Please ask for: Nicola Moore
Email: nicola.moore@arun.gov.uk
Telephone: Ext 37944
Our Ref: AB/19/22/HH
Your Ref:
Date: 3rd March 2022

Application for Planning Permission for Works or Extension to a Dwelling

Development: Proposed side extension, loft conversion, changes to external finishes, together with internal alterations and all associated drainage works
Location: 39 Priory Road Arundel BN18 9ET

JOB NO.	DRAWING NO.	REVISION
21099	2.03	B

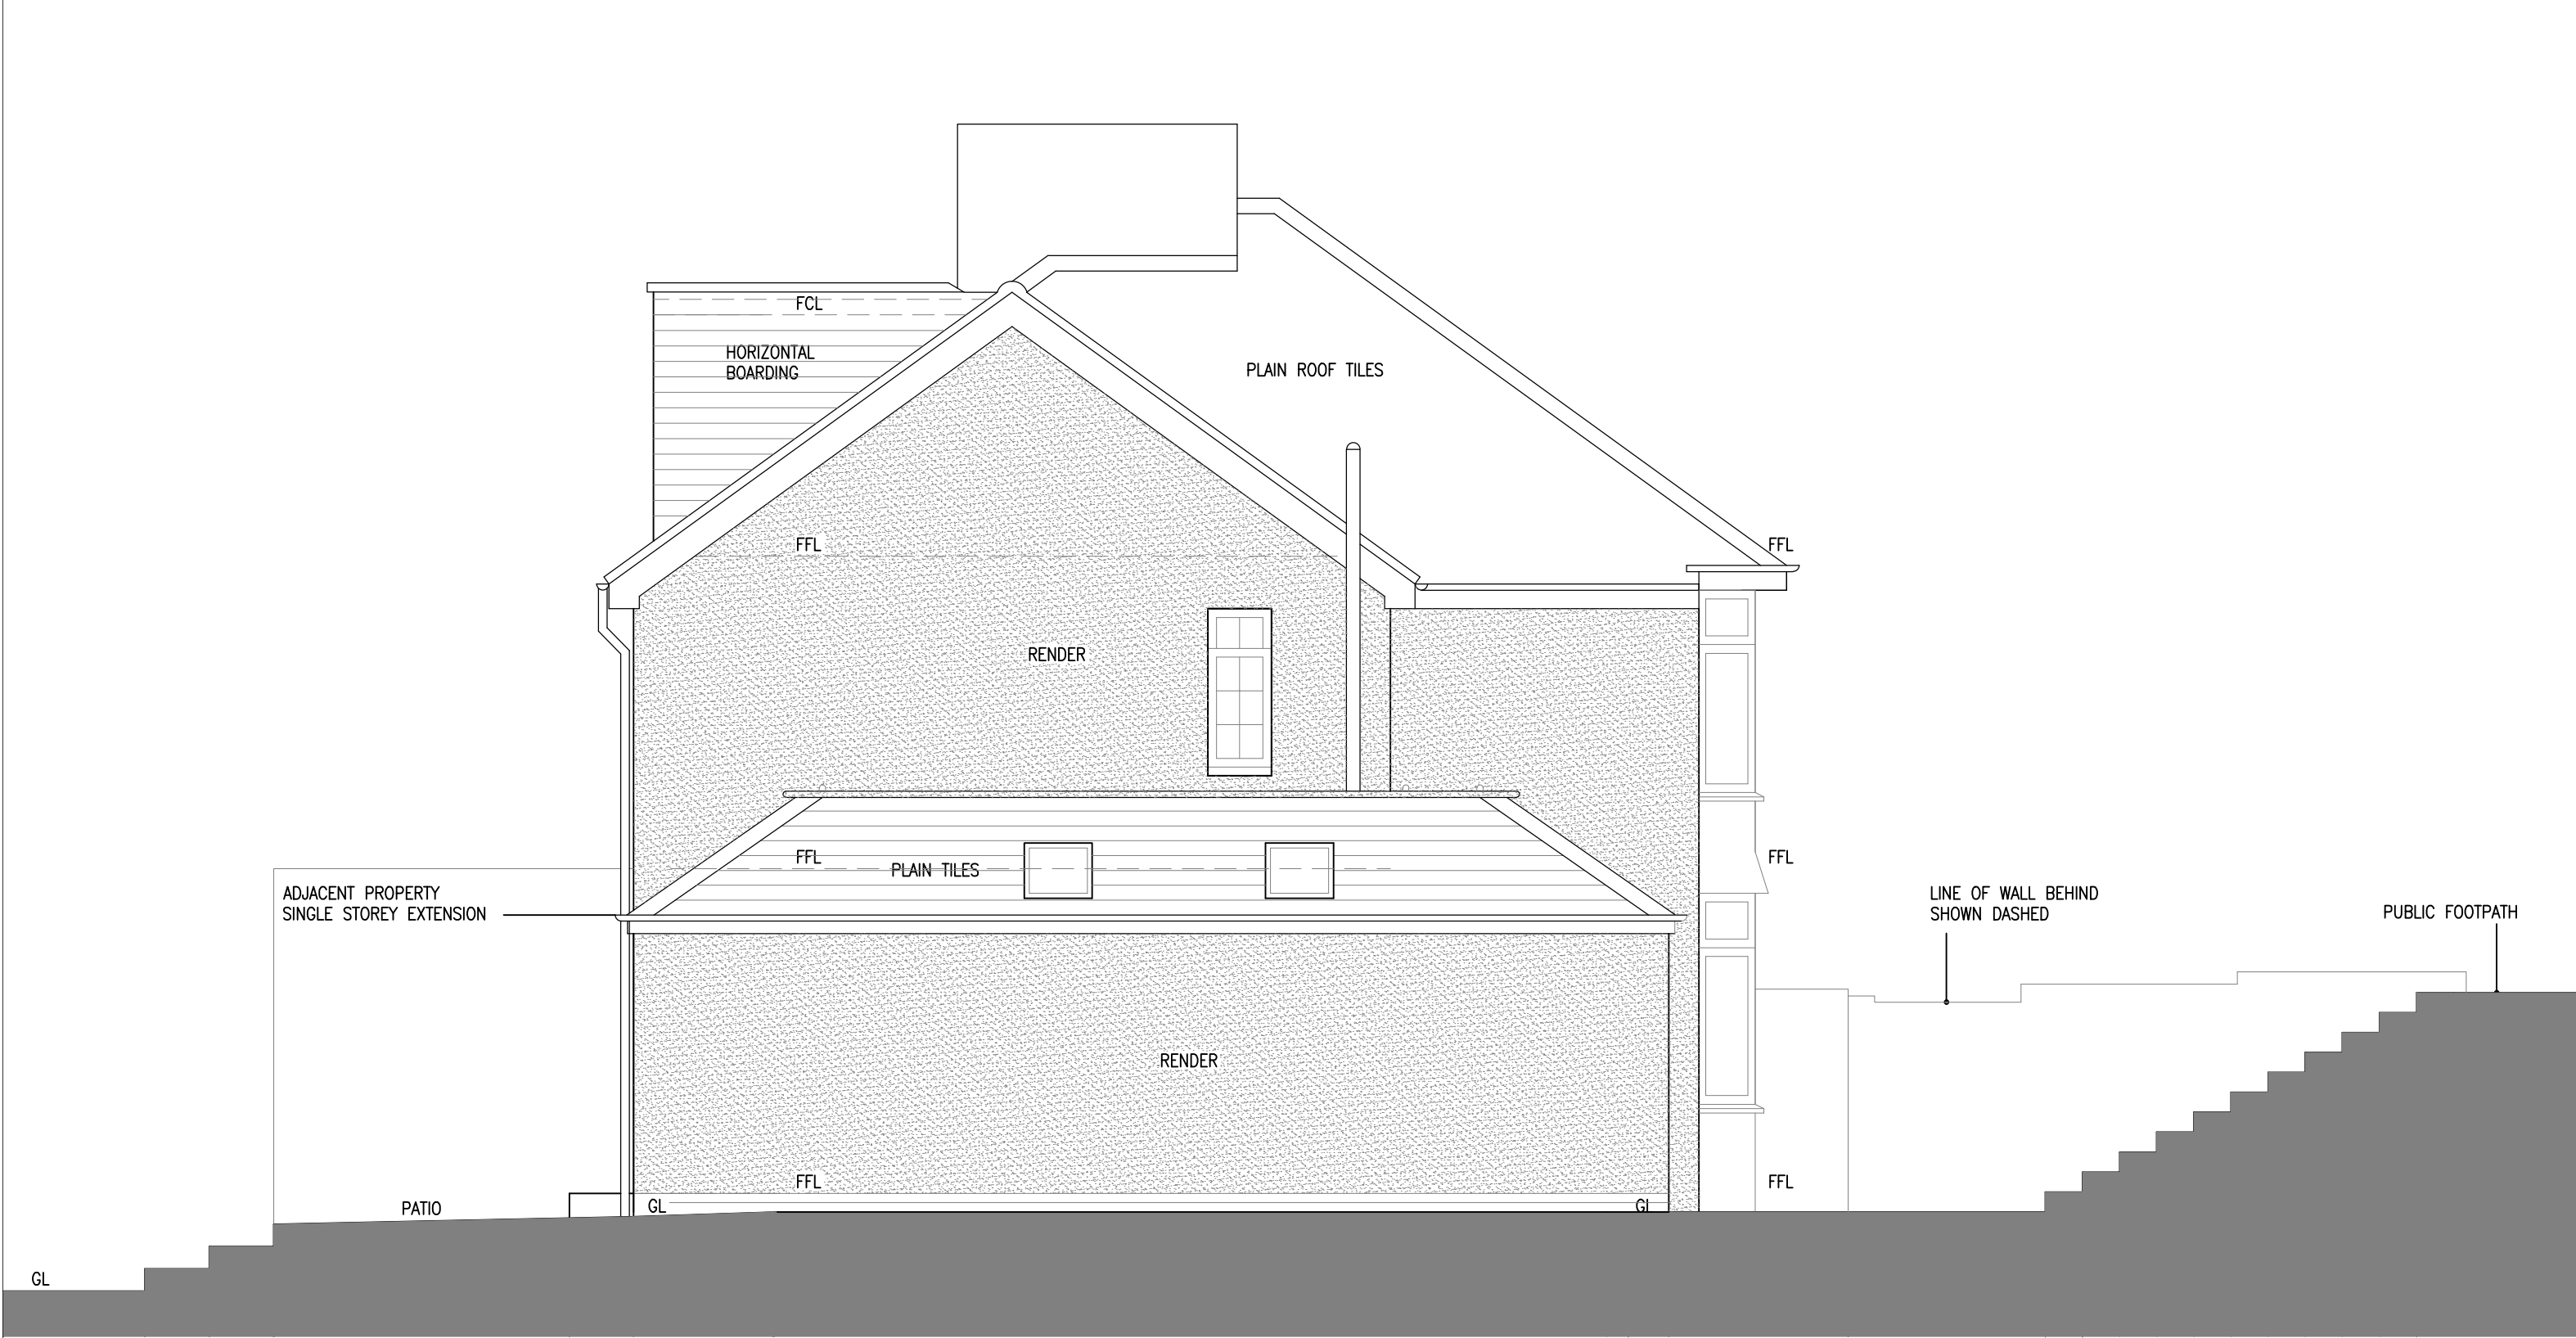
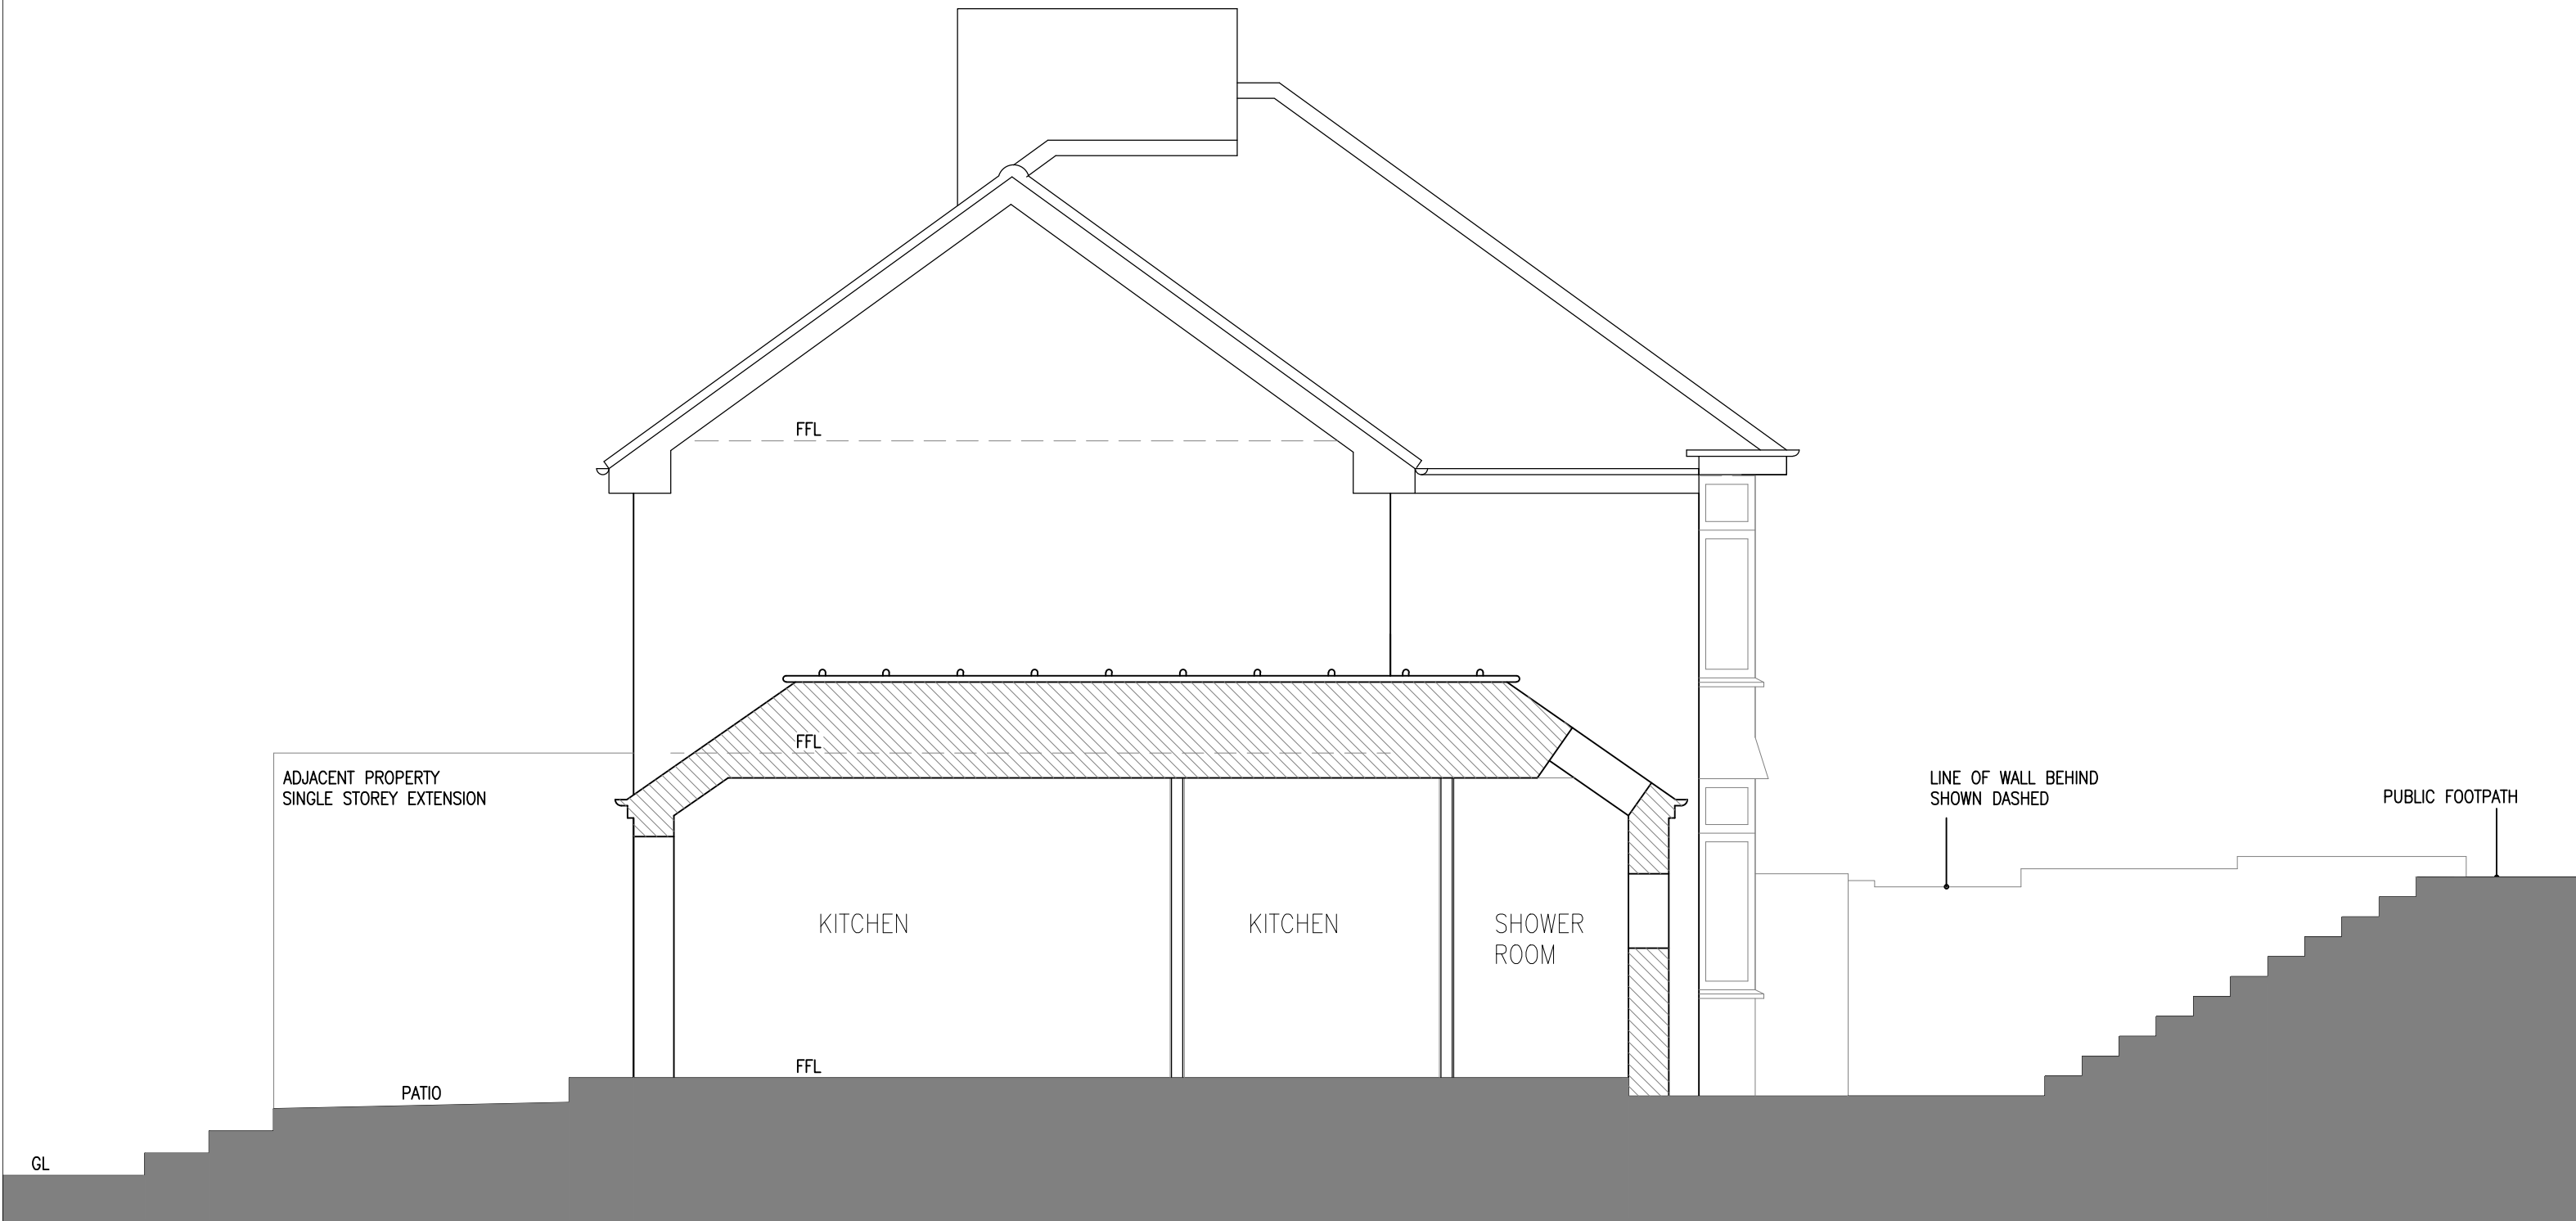
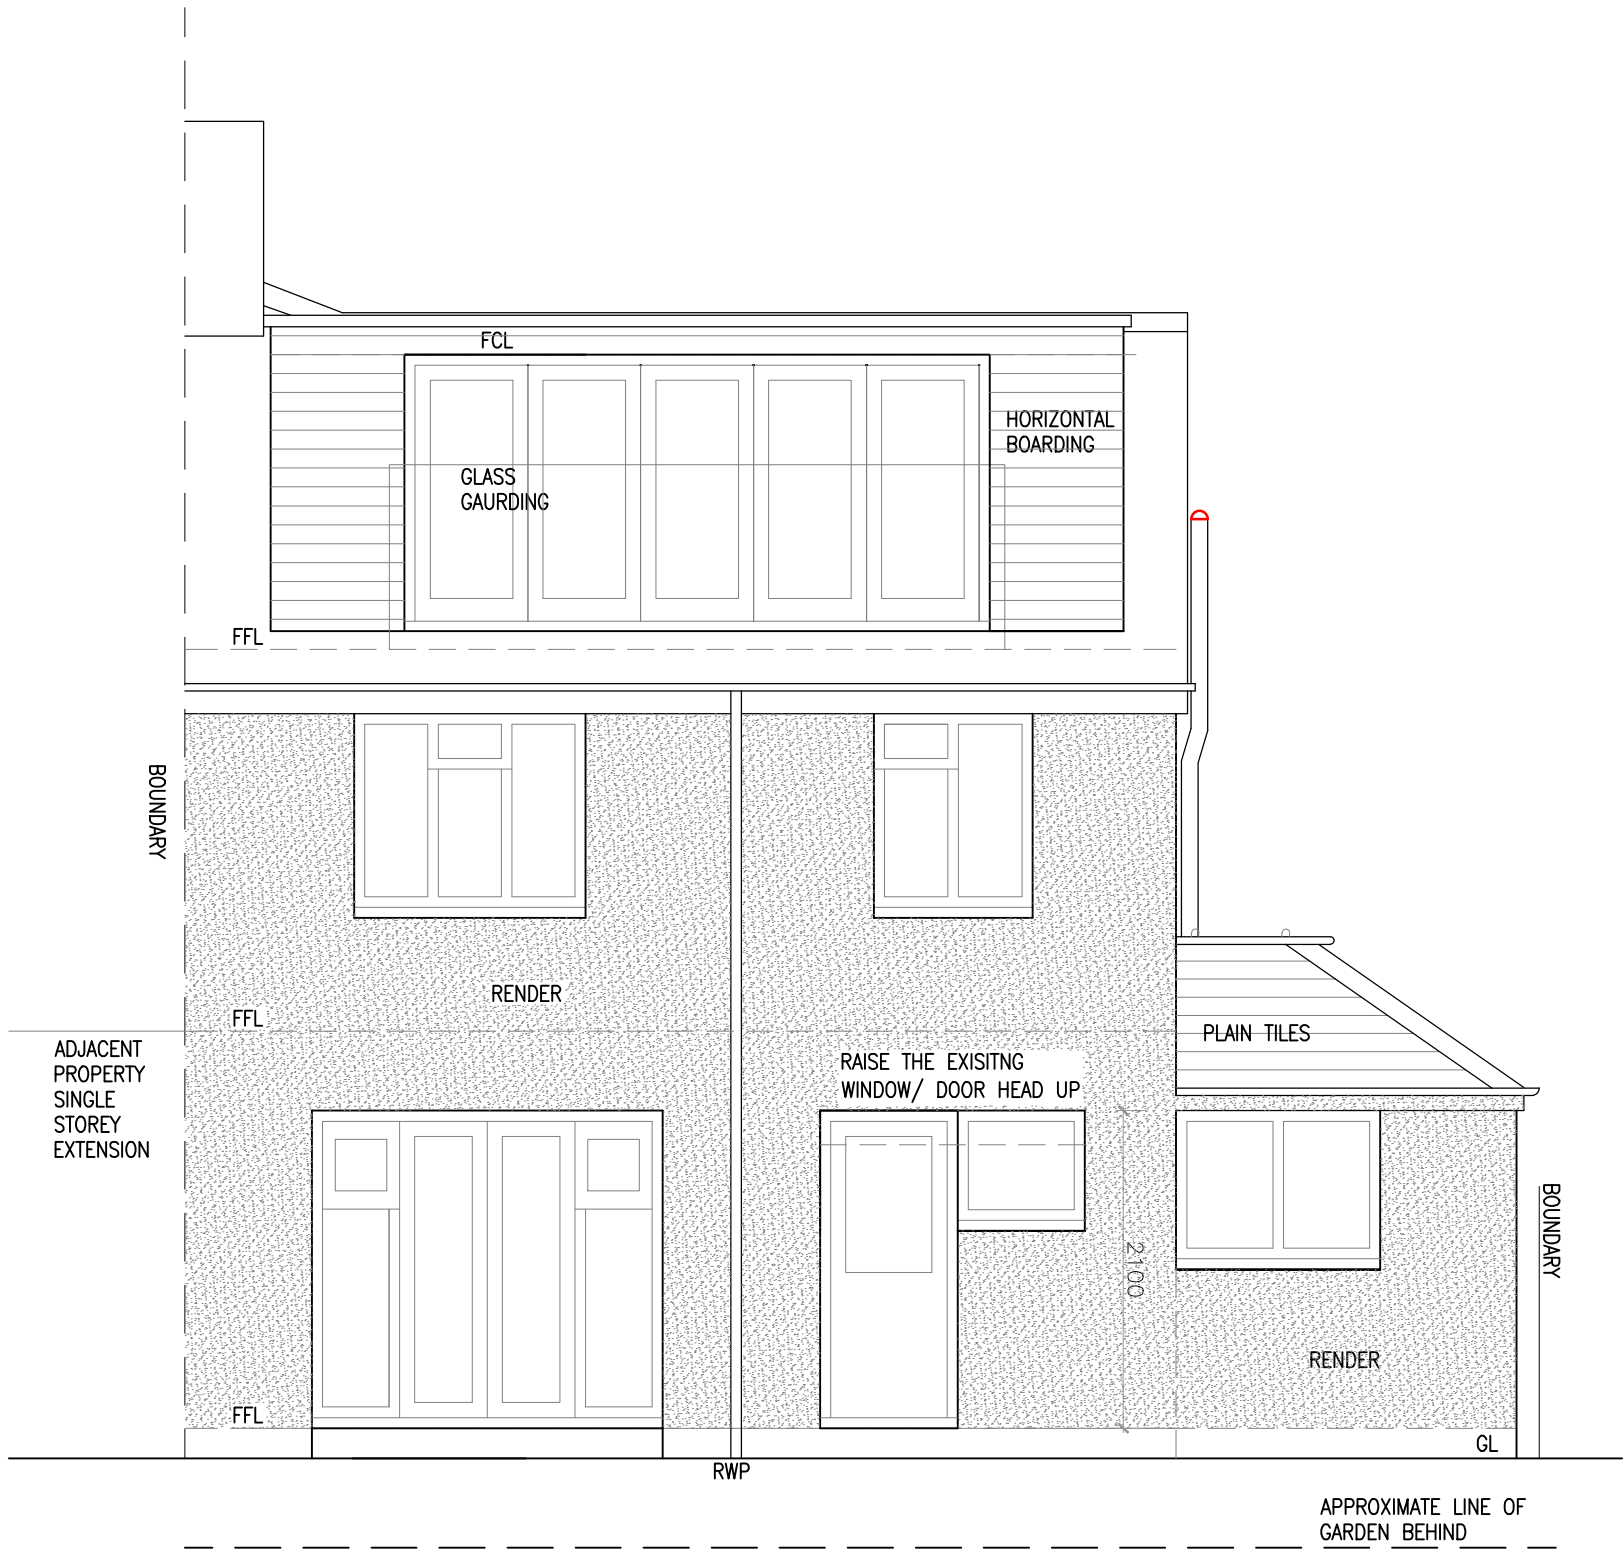
Dwg No 2.03 Rev A is titled Elevations and Section as Proposed, but the each elevation/section is titled existing. Please amend accordingly and re submit.
